**Consultation Response from KC,
Conservation & Design**

2022/93397 Highfields Centre, New North Road, Huddersfield, HD1 5LS

Discharge of conditions 3 (Construction Environmental Management Plan), 4 (cycle parking), 5 (electric vehicle charging), 6 (waste storage and collection), 7 (crime prevention), 8 (materials), 9 (windows schedule), 10 (boundary treatments), 11 (external lighting), 12 (sound insulation), 18 (landscaping) and 19 (Ecological Design Strategy) of previous permission 2019/90467 for conversion of former college buildings into 33 apartments including demolition of link canopy, partial demolition of link building, erection of additional storey to link building, and internal and external alterations (Listed Building within a Conservation Area)

Date Responded: 06.03.2023

Drawing Title: Floor Plans - all levels Building B

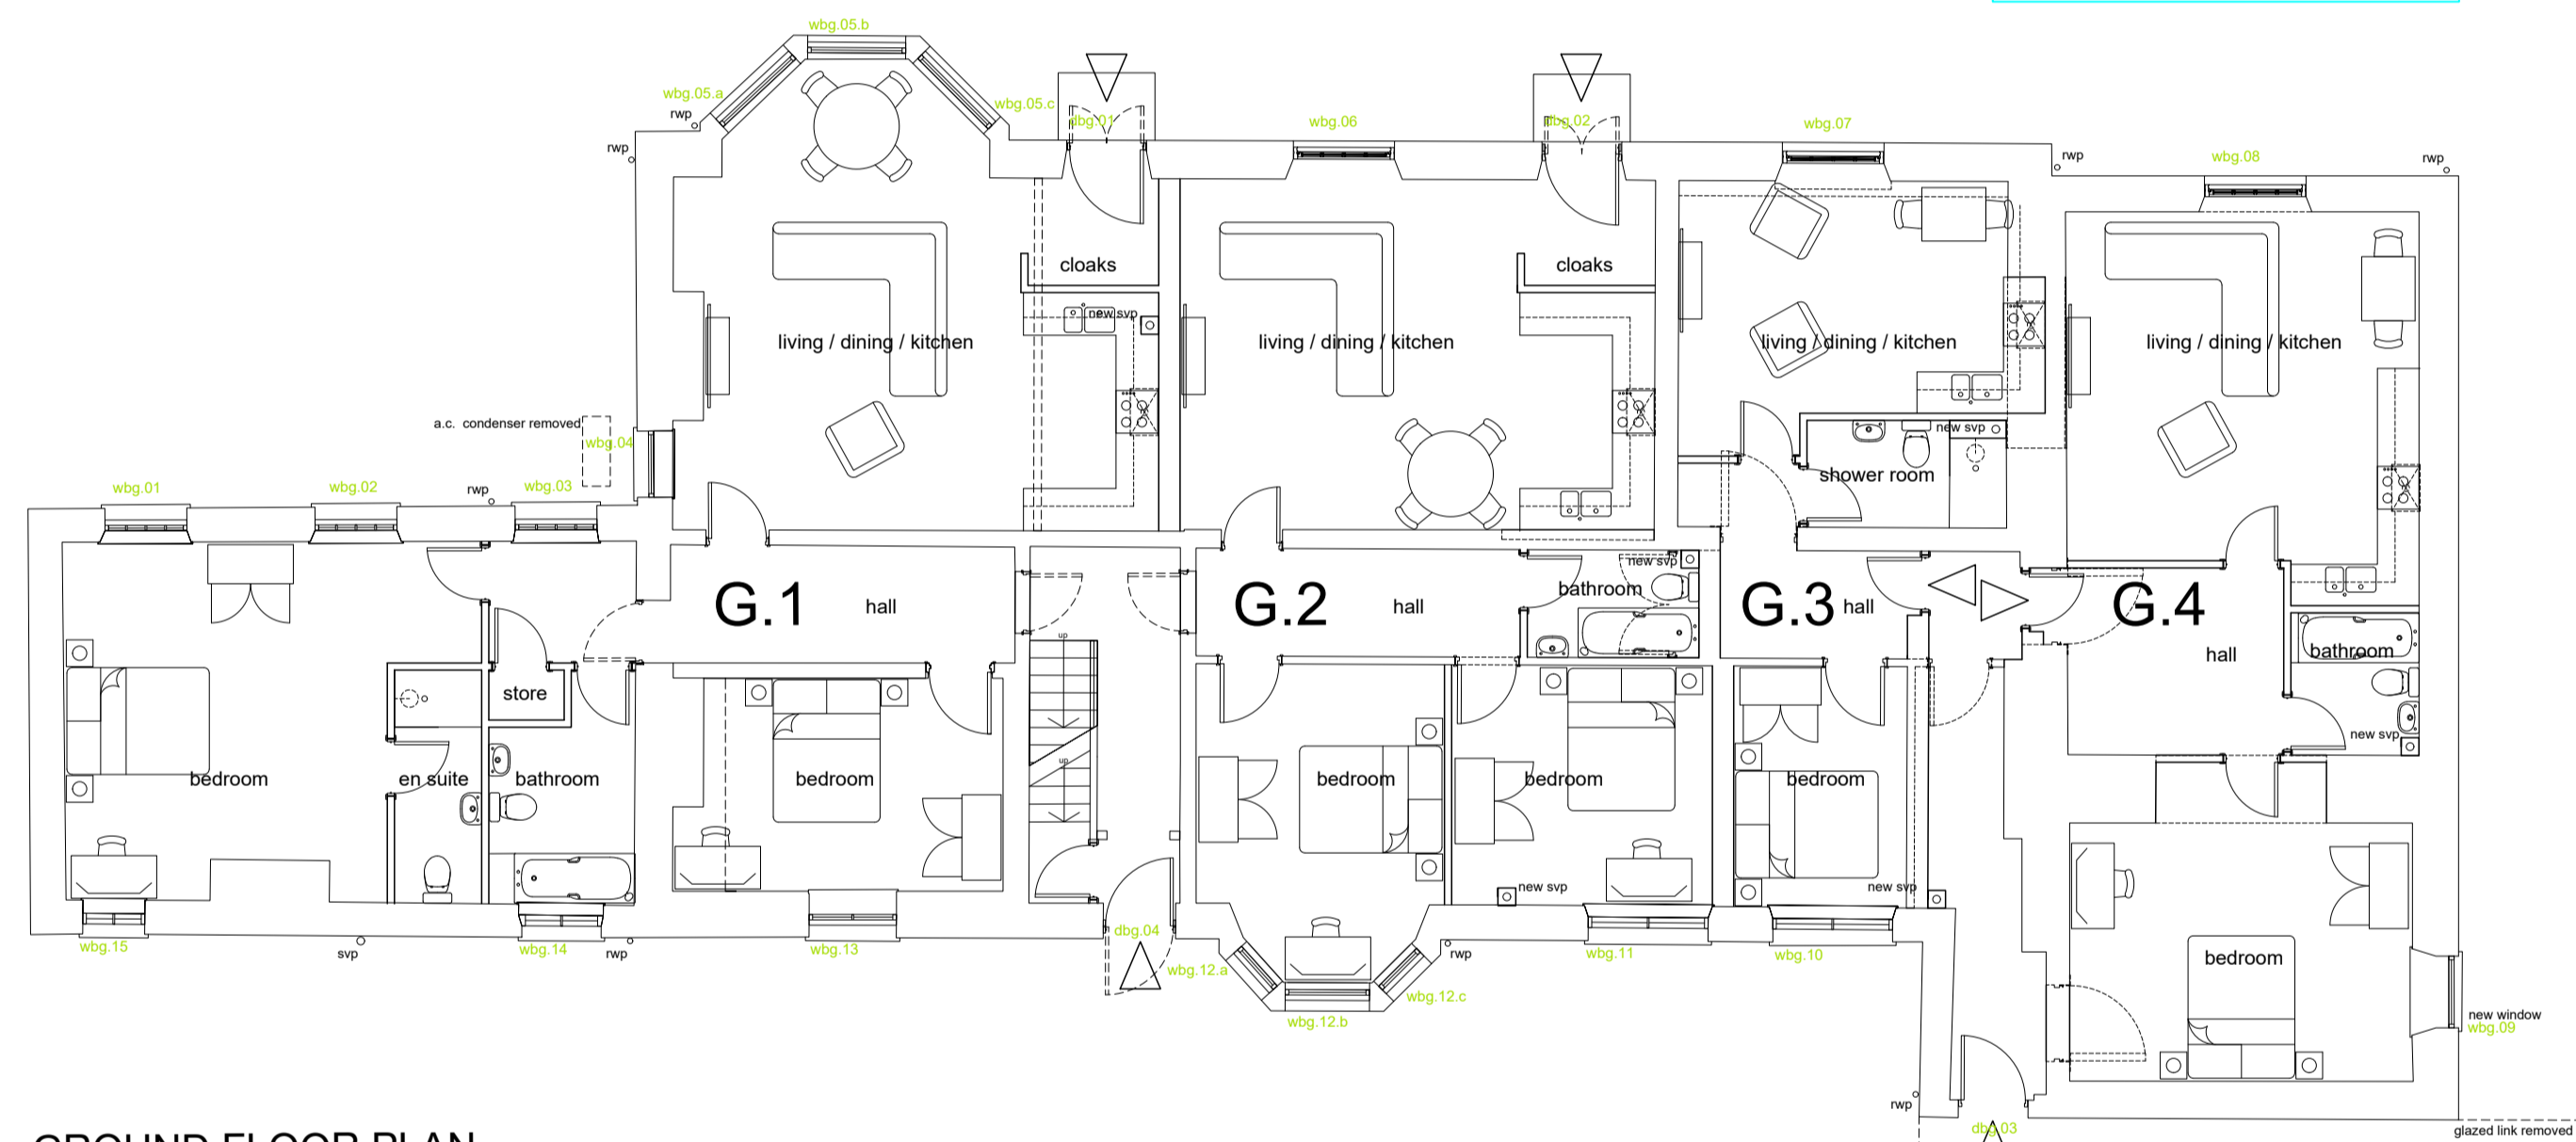
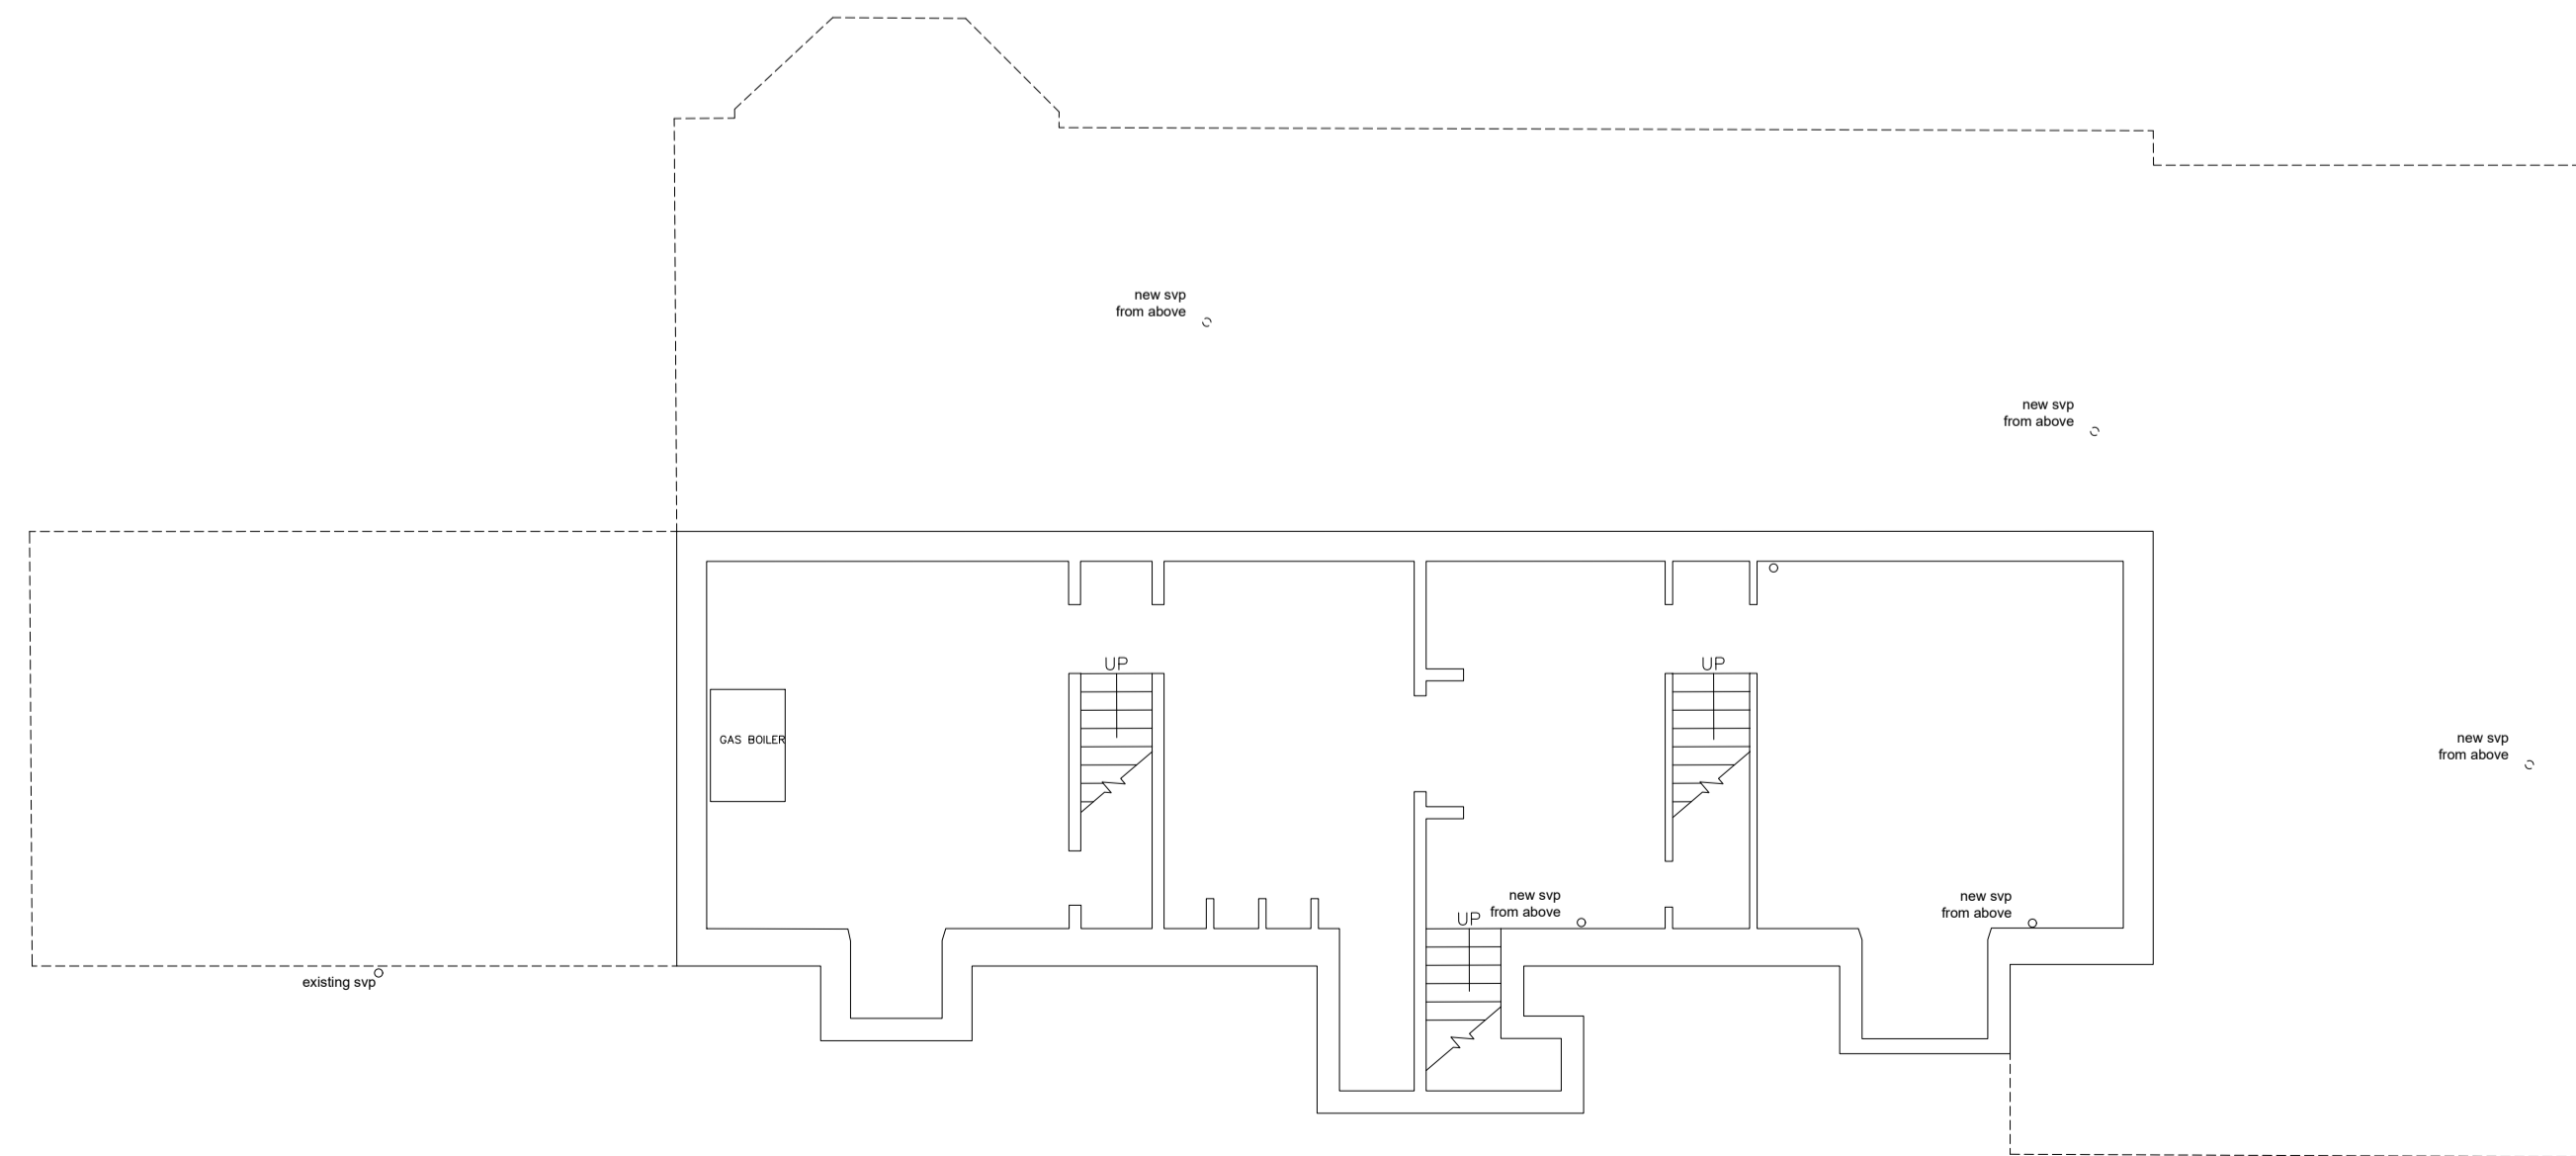
The current detail is insufficient. The plans denote windows to be retained and some which need to be replaced, however there is no specific detail for the windows. The previous condition clearly set out a schedule for all existing windows is required. The current details are insufficient, and we need a detailed schedule for each windows, providing the details required. We also need specific details for any replacement windows.
